From: Contact Centre (CRM) <contact@ribblevalley.gov.uk>
Sent: 20 June 2025 10:52
To: Planning
Subject: Planning Application Comments - 3/2025/0146 FS-Case-724607930

Planning Application Reference No.: 3/2025/0146

Address of Development: Evesons Barn
Simonstone Lane
BB12 7NU

Sheet Title
Existing General Arrangement & Visibility Splays

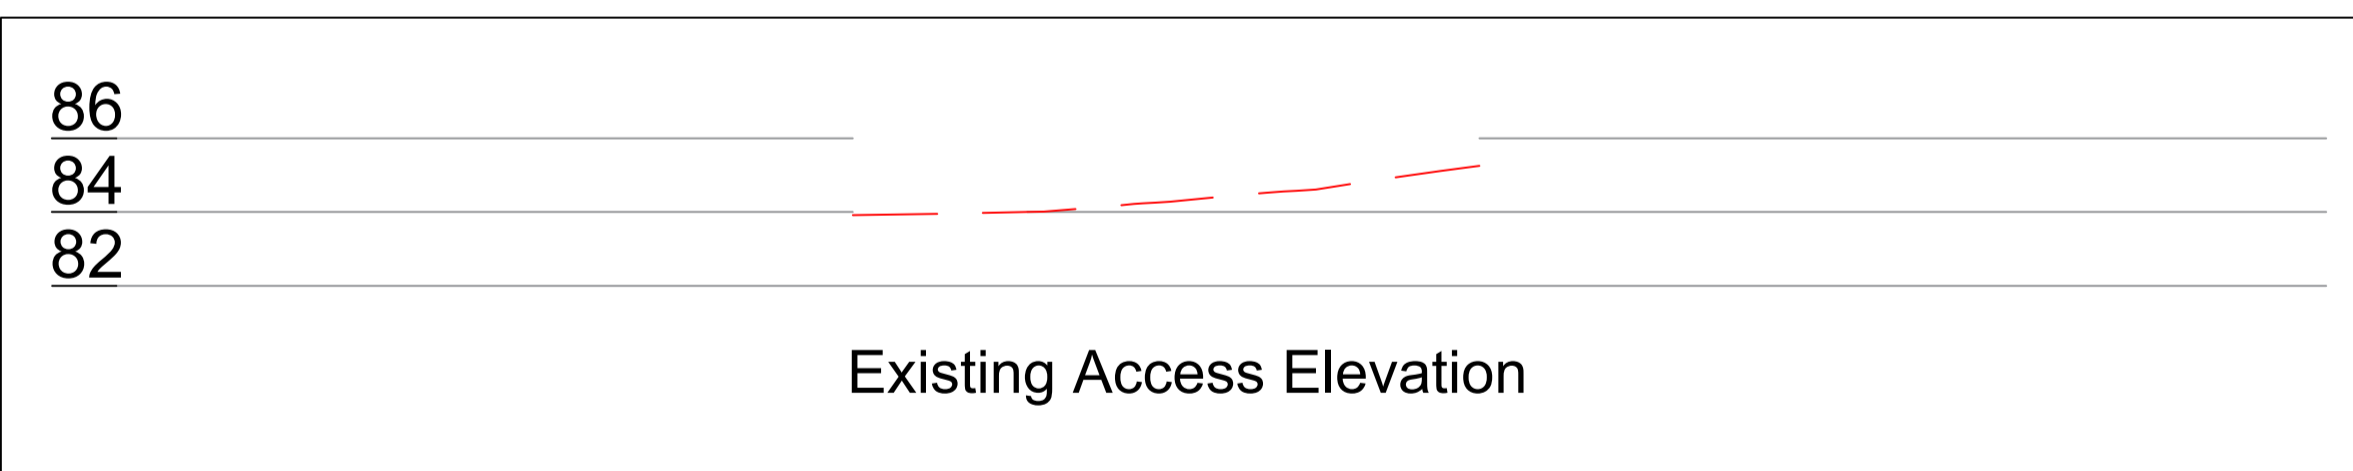
Comments: [REDACTED]. Traffic movement on Simonstone Lane has become increasingly hazardous, due to increased usage and speeding traffic and in my opinion, the existing access is not suitable for increased traffic movement due to its junction with Simonstone Lane and the restricted site lines when emerging onto it. I am therefore largely in favour of the proposal as it will, in the main, alleviate this problem. I would also urge that adequate steps are taken to avoid run off of surface water onto Simonstone Lane.
